**From:** <Pikefambily@aol.com>  
**To:** <jf@portlandmaine.gov>  
**Date:** 5/22/2014 4:34 AM  
**Subject:** Proposed building at 97 Cumberland Ave, Portland

Thank you very much for allowing me to look over plans and sketches today for the proposed construction at 97 Cumberland Ave. I have several serious concerns that I would like to bring up in regard to the proposal.

Preliminary Site Plan

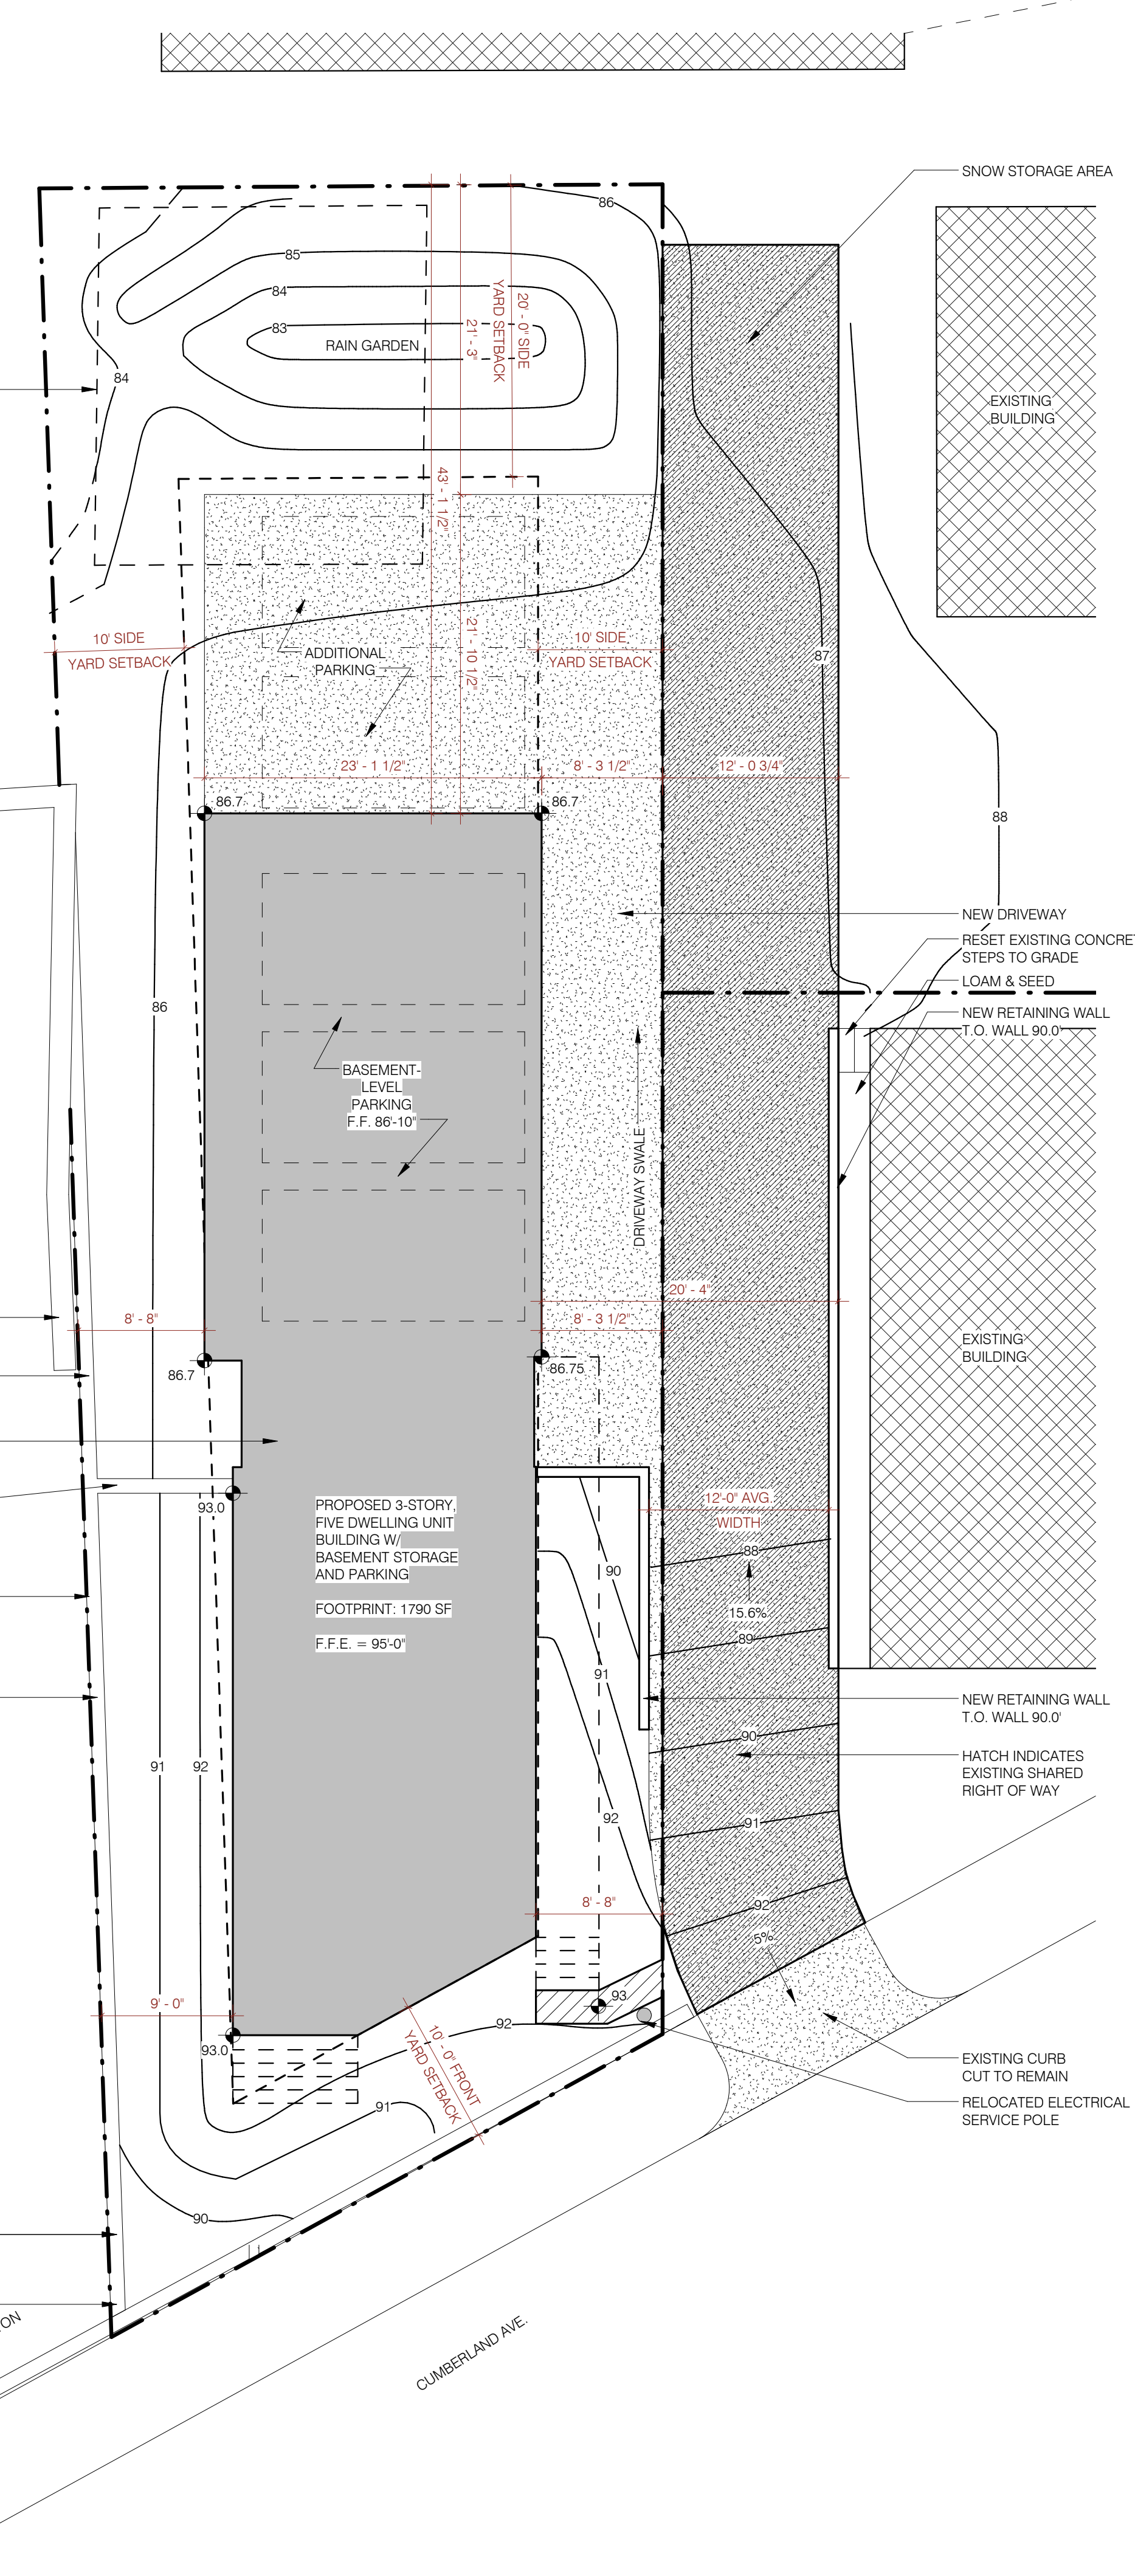
was built into the side of the hill over 100 years ago. The right of way runs along the downhill foundation side of my building. The currently proposed changes include the creation of a new retaining wall in the 14' wide right of way approximately 2 feet away from the foundation of my building and running the entire length of my building. The proposed plan is to raise the site elevation so much that it even requires the architect to call on the plan for alterations to be done to my building, including the "adjustment for downspout (on my building) to drain through new wall to pavement", as well as to "reset (the) existing concrete steps (to my basement) to grade".

SITE PLAN OF:
97 CUMBERLAND AVENUE
BY CUMBERLAND AVENUE
PORTLAND, MAINE

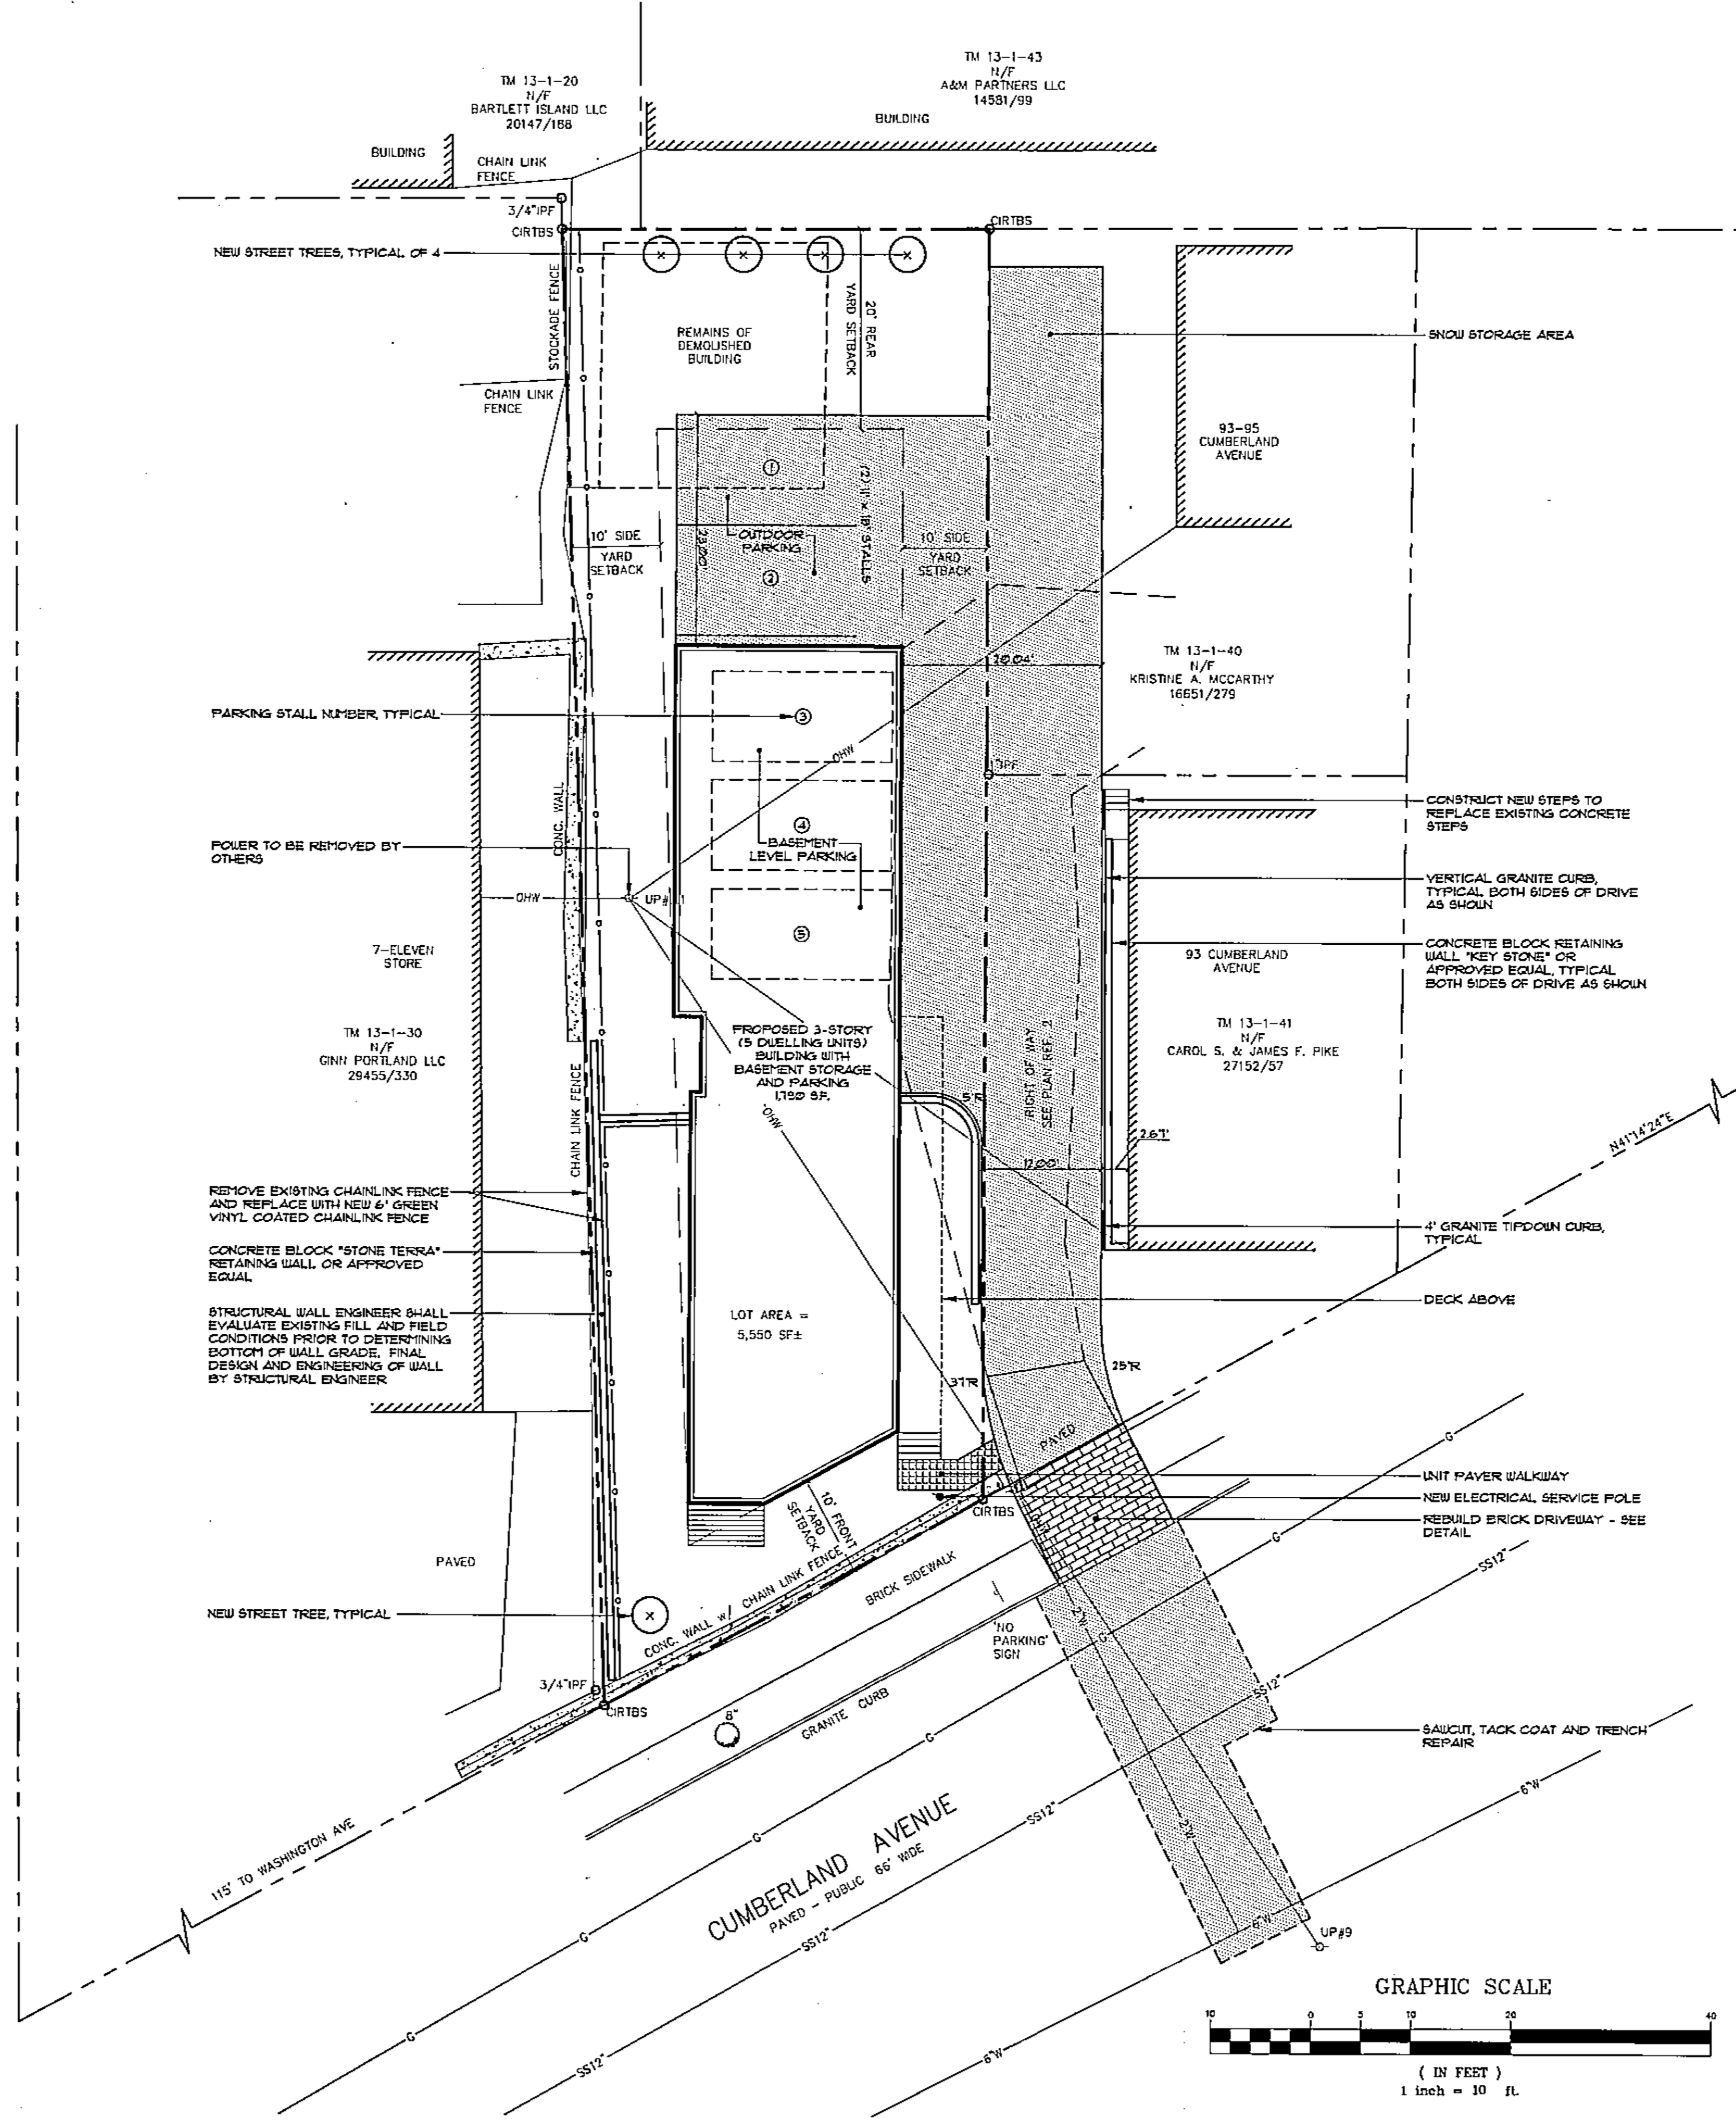
2. In addition to this proposed illegal change of use in the right of way, the submitted plans to create elevation changes to the right of way across my land are of very great concern. My building at 93 Cumberland Avenue

This proposal appears to leave me with a 2 foot wide ditch along the foundation of my building, which the plan offers to "loam and seed". The proposed paved width is 12', taking up the entire remainder of the right of way. Snow plowed along this newly paved way would quickly fill the ditch along my foundation and pile snow up against my basement windows, most likely flooding my basement. Rain water runoff from the newly created elevated pavement could easily do the same. My building has basement windows which would now be put partially underground in a gully in this proposal. My basement steps have always run in the upward direction, not the downward direction.
